From: Sue Oakley
Sent: 06 November 2018 09:11
To: DCAdmin
Cc: Matthew Woodward
Subject: RE: 2018/92593 Jessop's Mill revised conservation response

From: Sue Oakley
Sent: 25 October 2018 10:34
To: DCAdmin <DC.Admin@kirklees.gov.uk>
Cc: Matthew Woodward <Matthew.Woodward@kirklees.gov.uk>
Subject: 2018/92593 Jessop's Mill conservation response

I have considered this proposal for the conversion of this former mill into 20 apartments along with the change of use of the lower ground floor nightclub (entrance from Bradford Road) into a wine bar. The three storey building which is the subject of this application is part of Jessops Mill, a grade II listed building dating back to circa 1870 with later alterations, and this structure would be considered to be curtilage listed. The site is located within the Station Road, Batley Conservation Area and it is currently vacant, clearly in a state of disrepair and in need of restoration.

SOUTH FACING ELEVATION

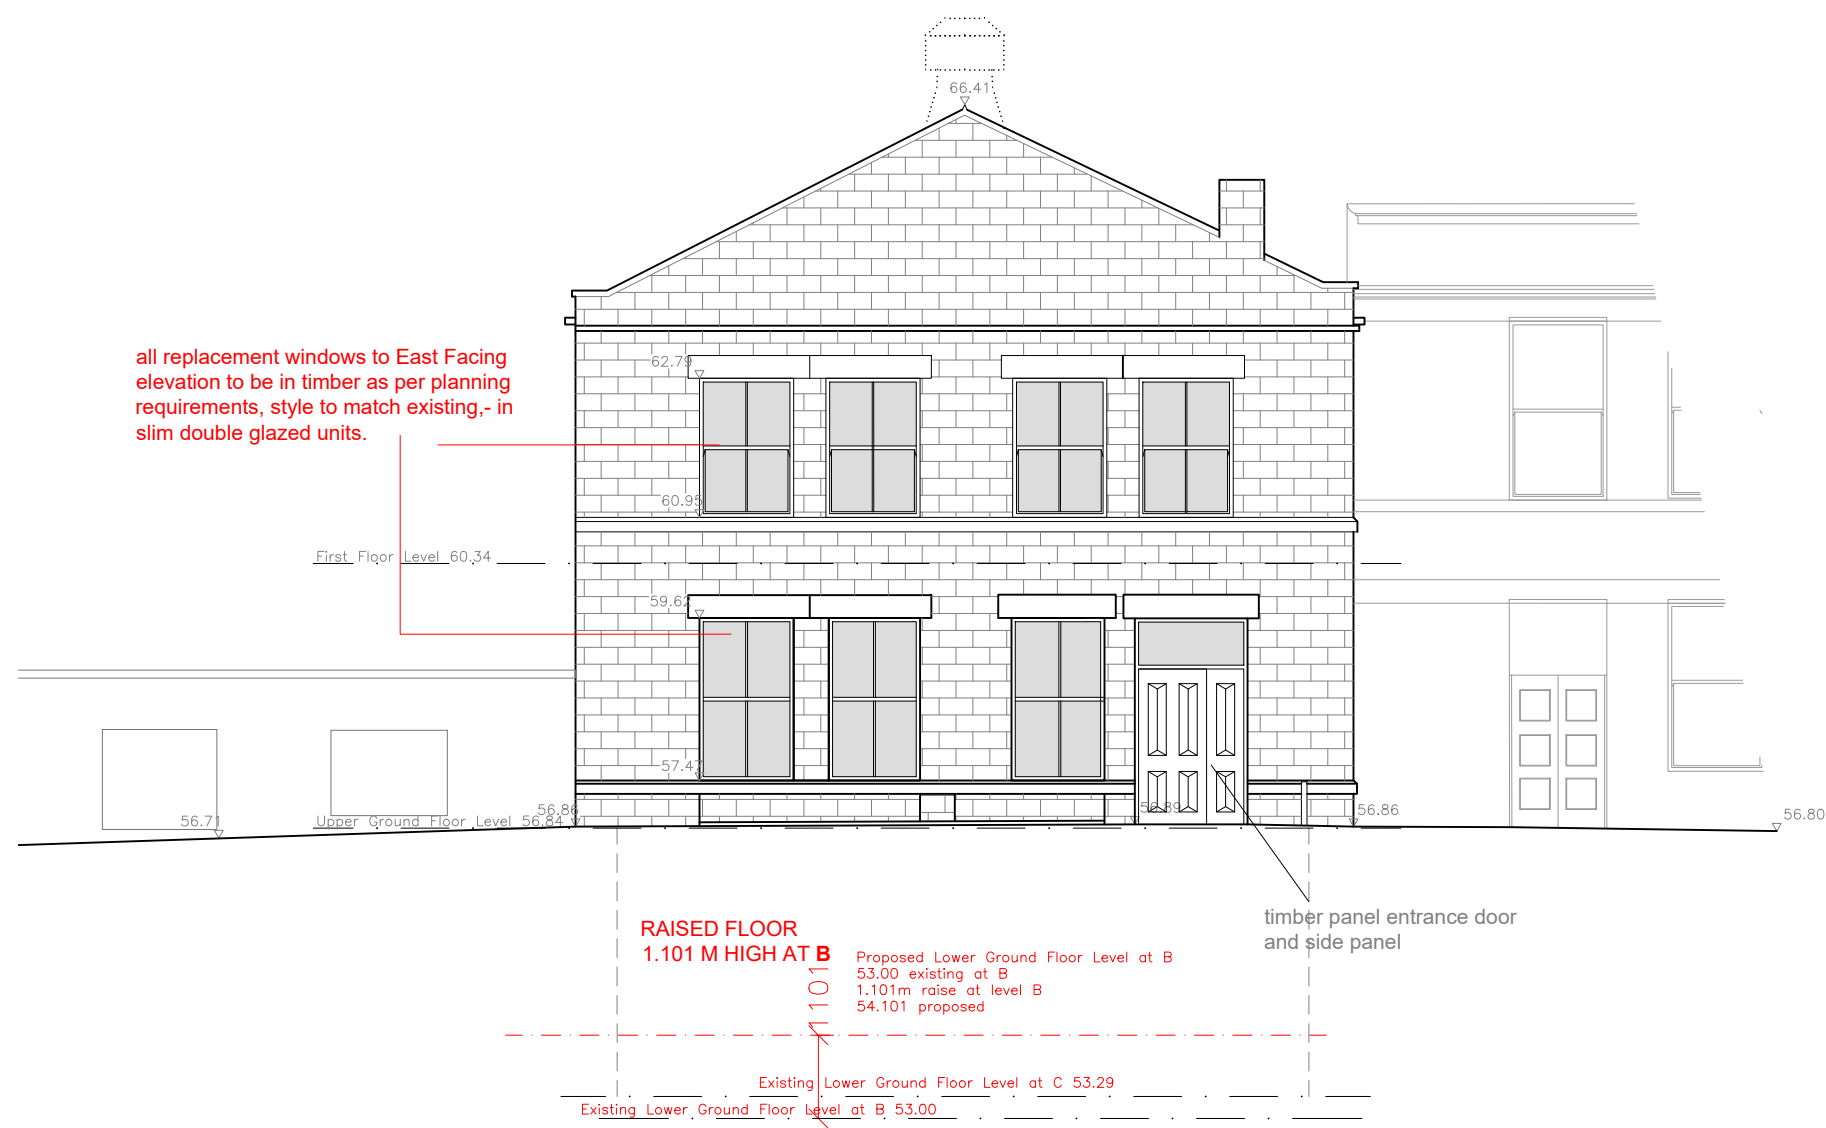
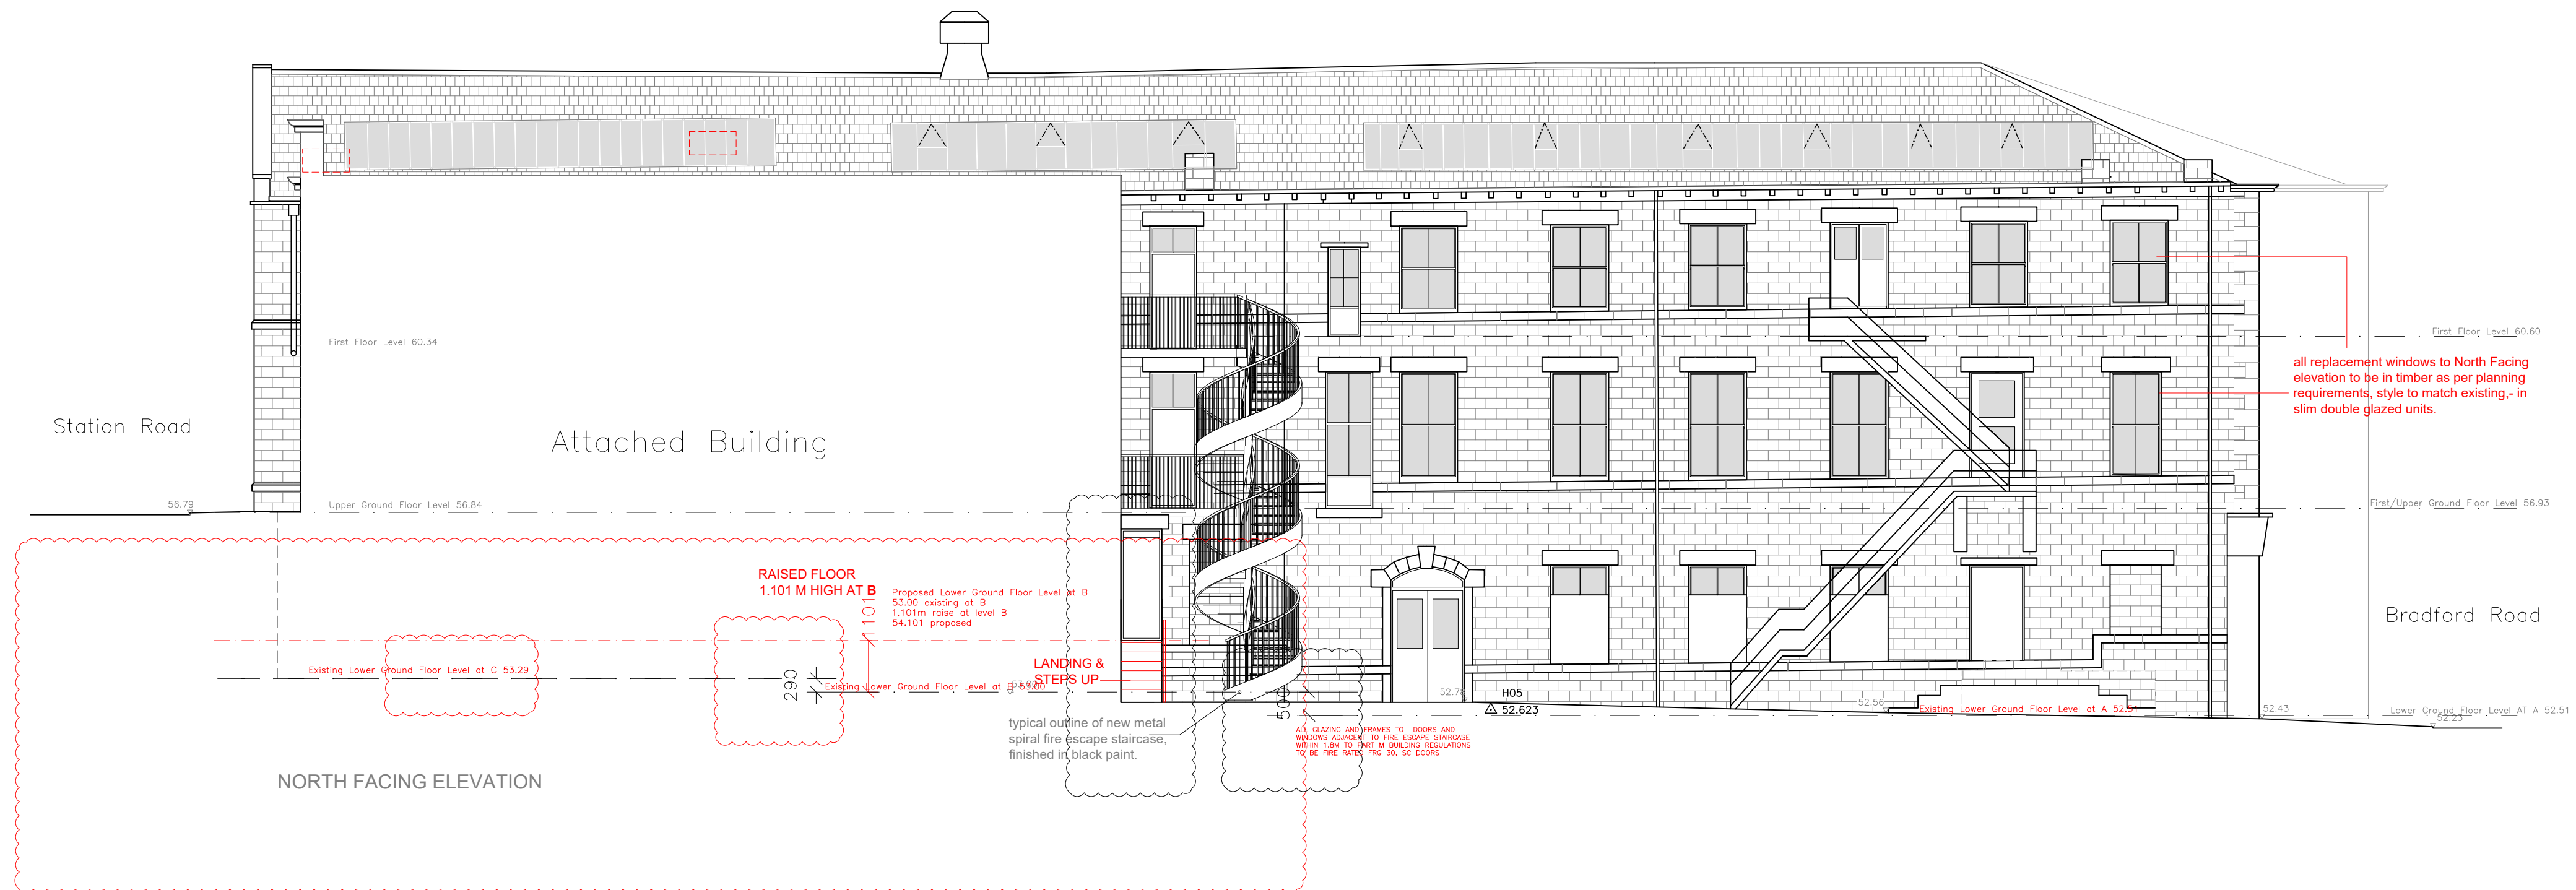
Following receipt of the revised drawing 18.2030.11D I have the following comments. The drawing has been revised to show aluminium windows on the less prominent and less significant south elevation. Replacement windows to all other elevations will be in timber, style to match the existing historic windows and with slim double glazed units. This amendment is acceptable and the window details including colour, depth within the reveals, profiles etc should be provided as a planning condition.

The proposal includes the insertion of additional door and window openings to the south elevation with stone cills, heads and reveals to match the existing. White powder coated aluminium windows with slim profile frames are proposed for all existing and new windows including those on the Bradford Road and Station Road elevations. I have no concerns about the additional windows but I do have concerns about the replacement of historic timber windows with aluminium and would prefer new windows to be timber framed, replicating the original designs. Double glazing would be acceptable.

The infilling of the small opening on the south elevation is acceptable although the cill and head should be retained and Juliet windows to the basement level are acceptable. Details of opening lights should be provided, along with details of the automatic window opening vents and fire escape window details.
